Re: Planning Application BN/128/19/OUT – For a 70 bedroom 2 storey Care Home plus 14 assisted living bungalows to be built on land adjoining "Highfield" Yapton Road, Barnham.

It is with great concern that we have today learned of the Planning Application for the proposed building of a care home complex in the field attached to "Highfield" in Yapton Road Barnham, which is directly opposite our home and we formally wish to oppose this application in the strongest possible terms for the following reasons.

CLIENT  
ORCHESTRA LAND  
DRAWING  
SITE PLAN

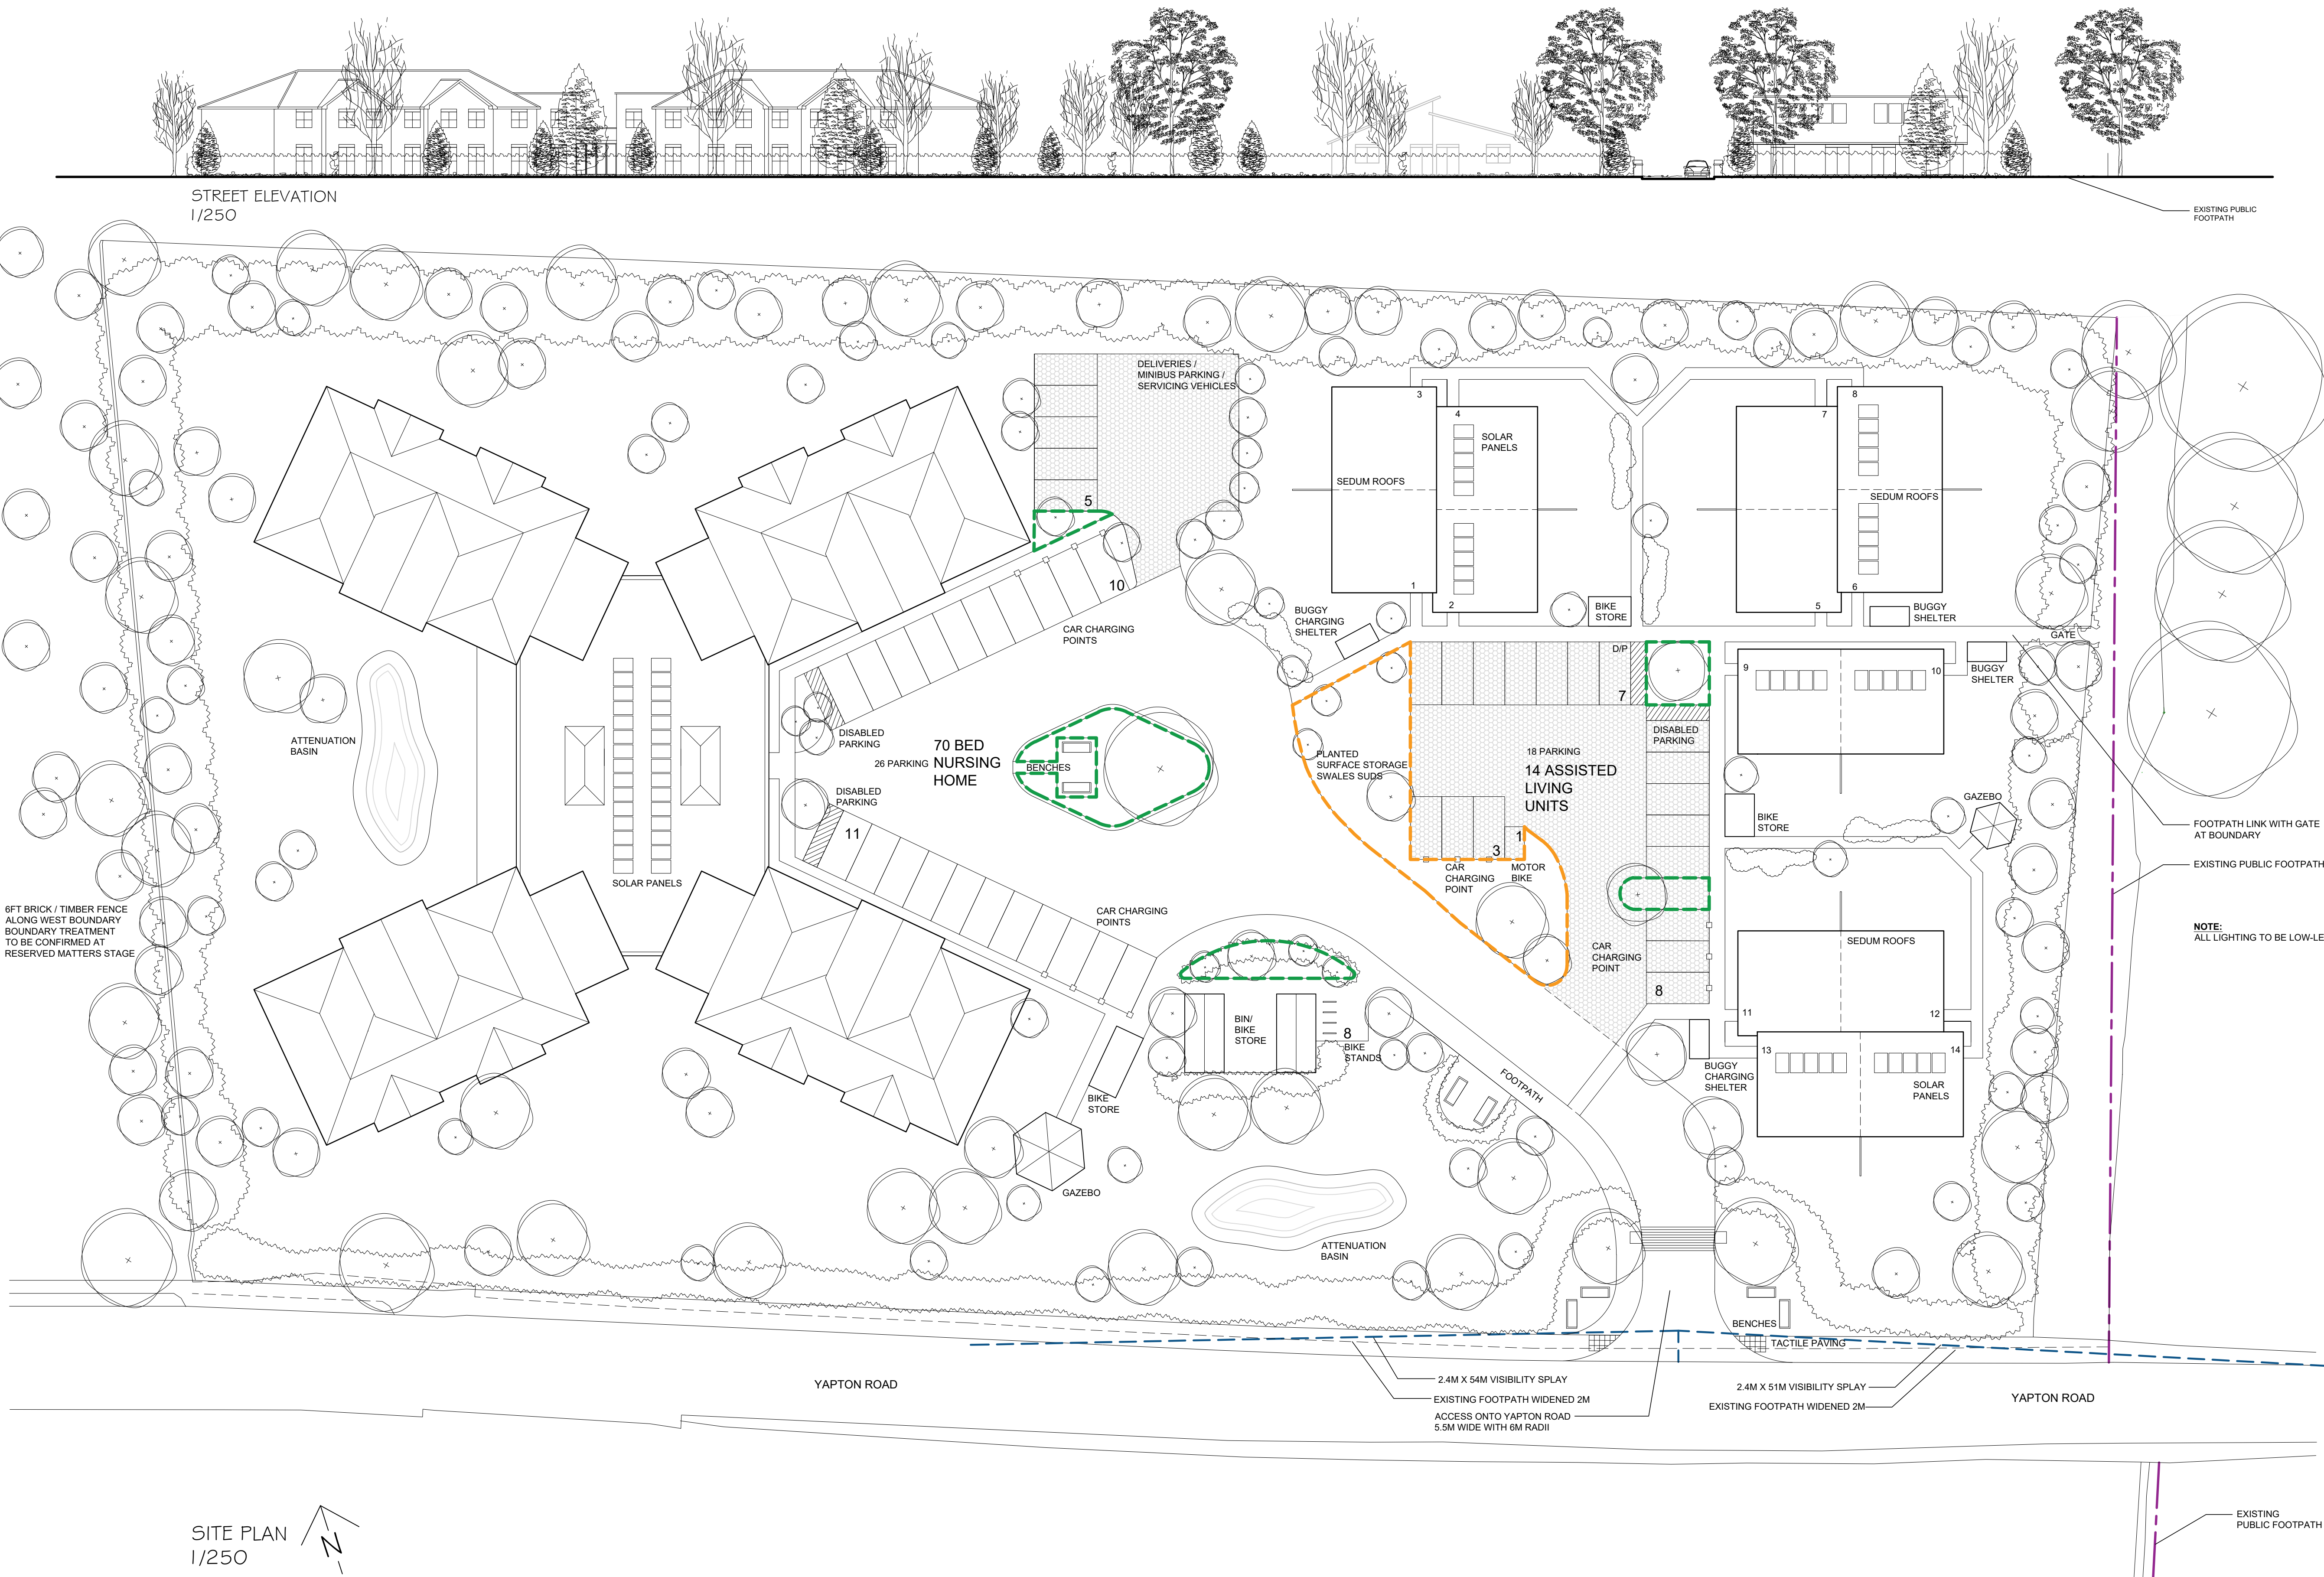
1) Road Safety – This road and the single footpath are both extremely narrow and although in a 30mph speed limit few cars take notice. Over the last 3 decades the traffic on this road has increased considerably beyond belief. The building of new properties and therefor an access road will only cause more traffic and with a new junction to negotiate the dangers can only be increased.

This complex will not be in keeping with the local area due to night time lighting and a 2 storey main complex in an over developed small space, resulting in loss of privacy by the residents due to being overlooked by the main building.

As the proposed site will be largely covered by concrete and block paving etc I presume that new drains will connect to our existing old drains and surface water will head south towards the flood plain at Flansham passing under or over our ground to get there!
